Jeanie Bourke - 722 Congress St

From: Amy Ferrer Rogers <amy@ferrerdesign.com>
To: Jeanie Bourke <JMB@portlandmaine.gov>
Date: 9/17/2014 2:01 PM
Subject: 722 Congress St
Attachments: A1.1 FLOOR PLAN.pdf; A2.0 INTERIOR AND EXTERIOR ELEVATIONS.pdf; A3.0 BUILDING SECTIONS.pdf; A3.1 WALL SECTIONS AND PARTITION TYPES.pdf; G1.0 COVER.pdf

Attached please find updated drawings for 722 Congress St (application No. 201401574) for your review.

A2.0  
INTERIOR & EXTERIOR  
ELEVATIONS

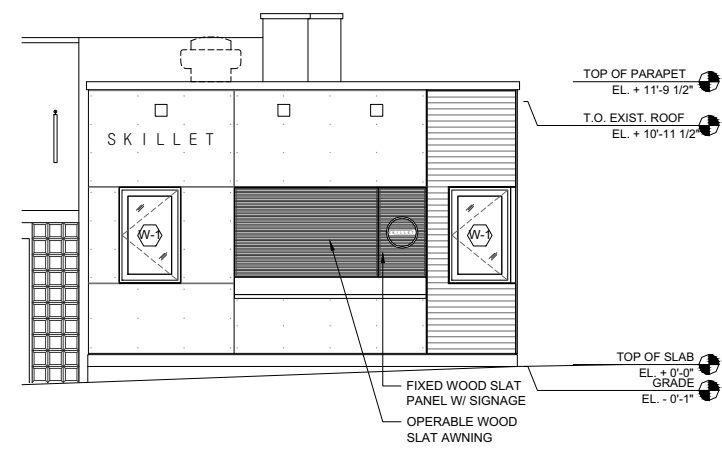
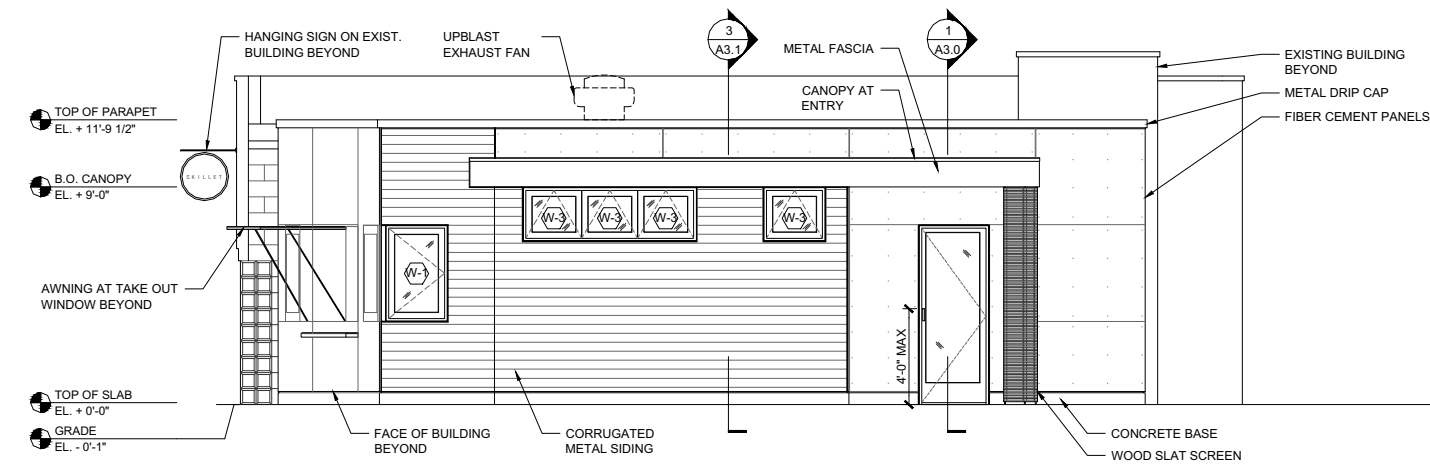
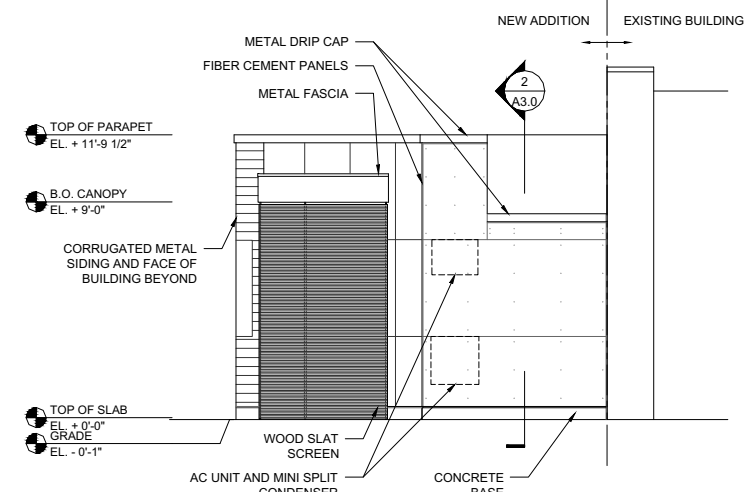
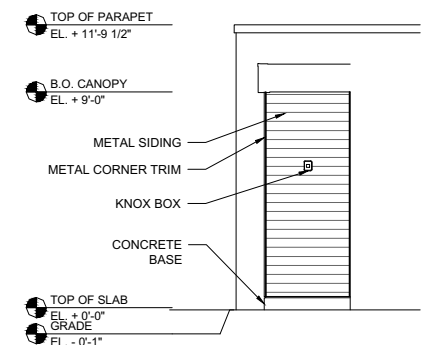
I've spoken to the State Fire Marshal regarding the barrier free permit. He confirmed that the bathroom does not need to be ADA compliant, but that the entry should be. The enclosed plan, elevations and building section sheets reflect this.

I've updated the exterior elevations to show the exhaust hood per your request.

A3.1  
WALL SECTIONS &  
PARTITION TYPES

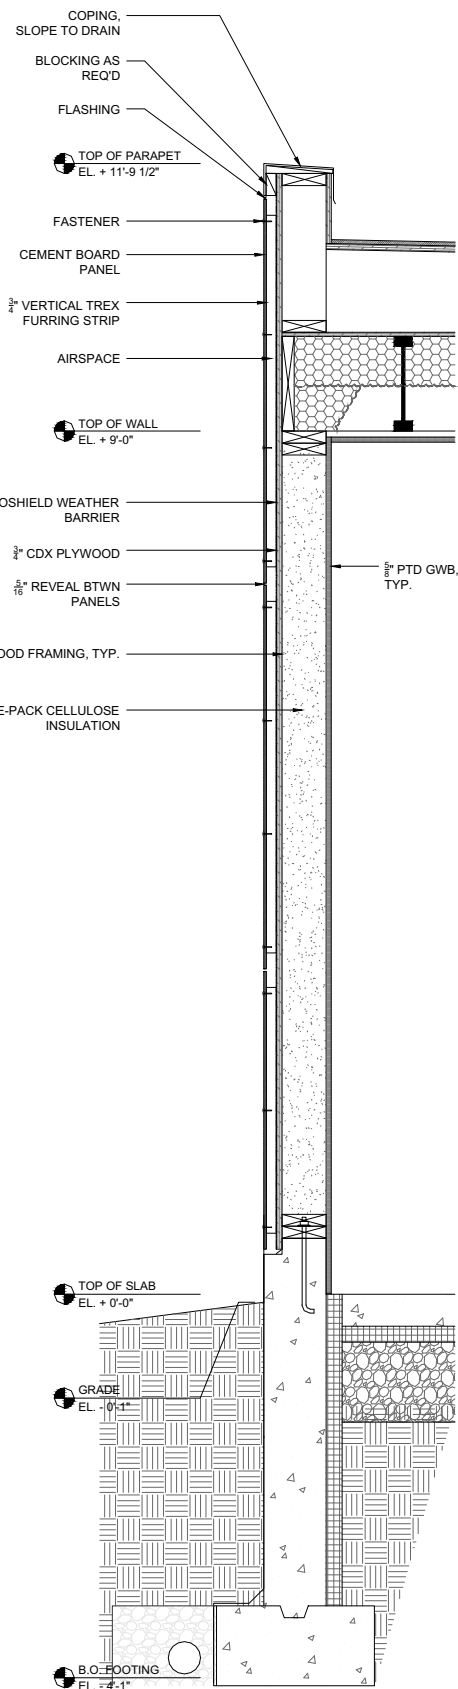
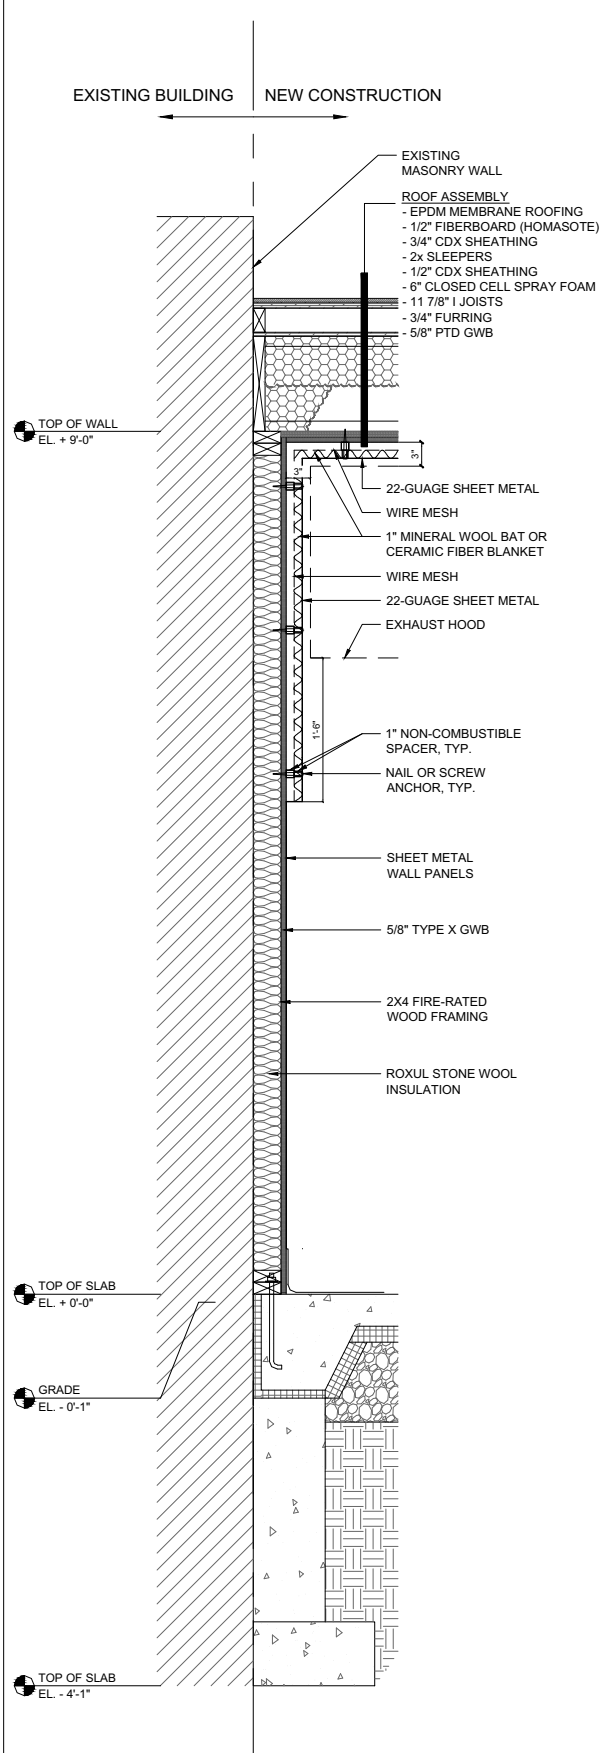
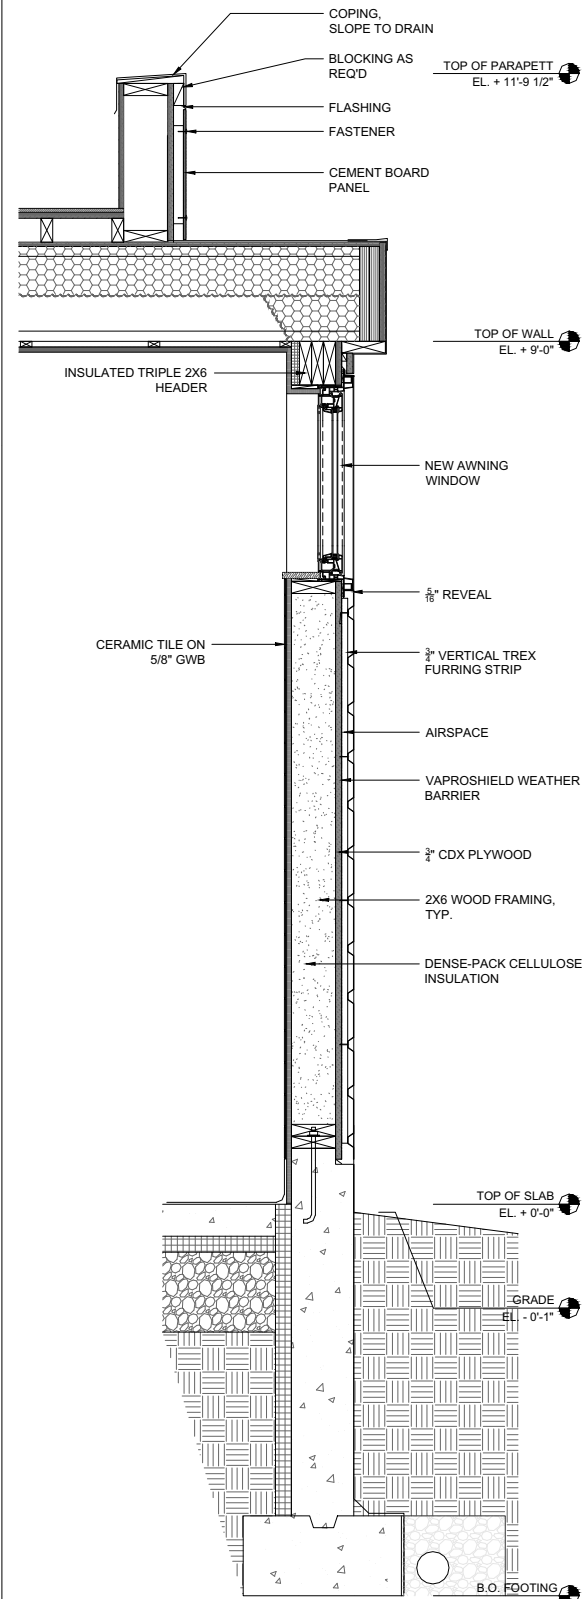
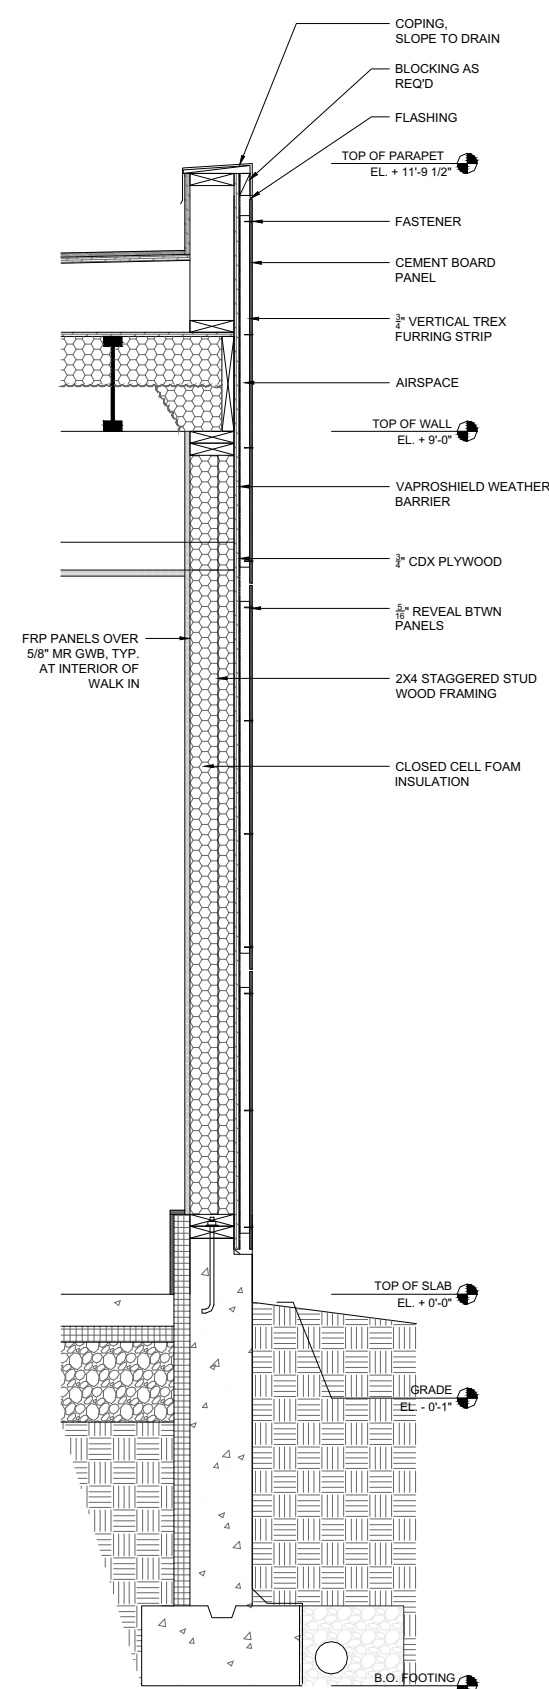
I've updated the wall sections to reflect the required clearance reduction system.

C1.0  
COVER SHEET

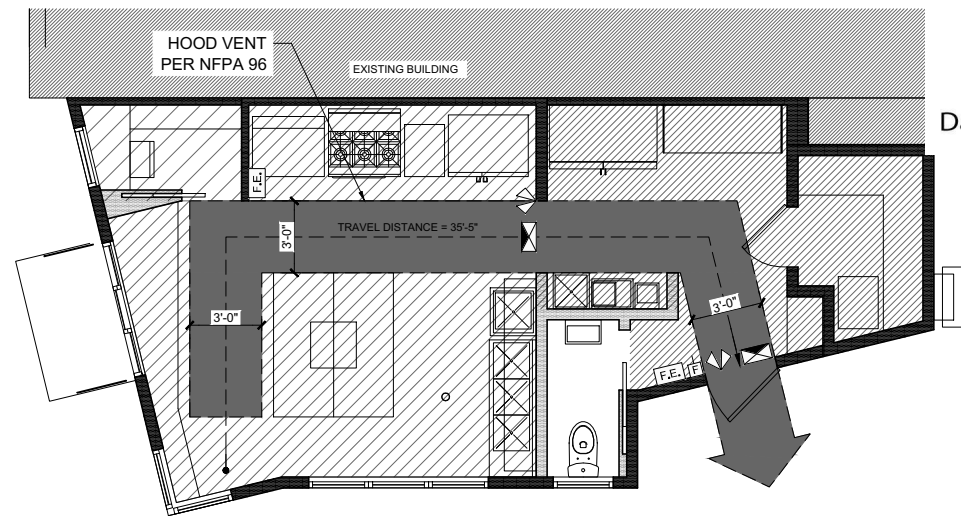
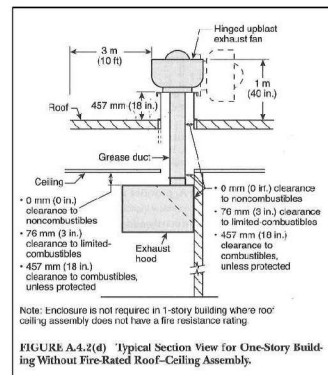
I've updated the cover sheet to reflect the relevant U-value information from Table 502.1.2.
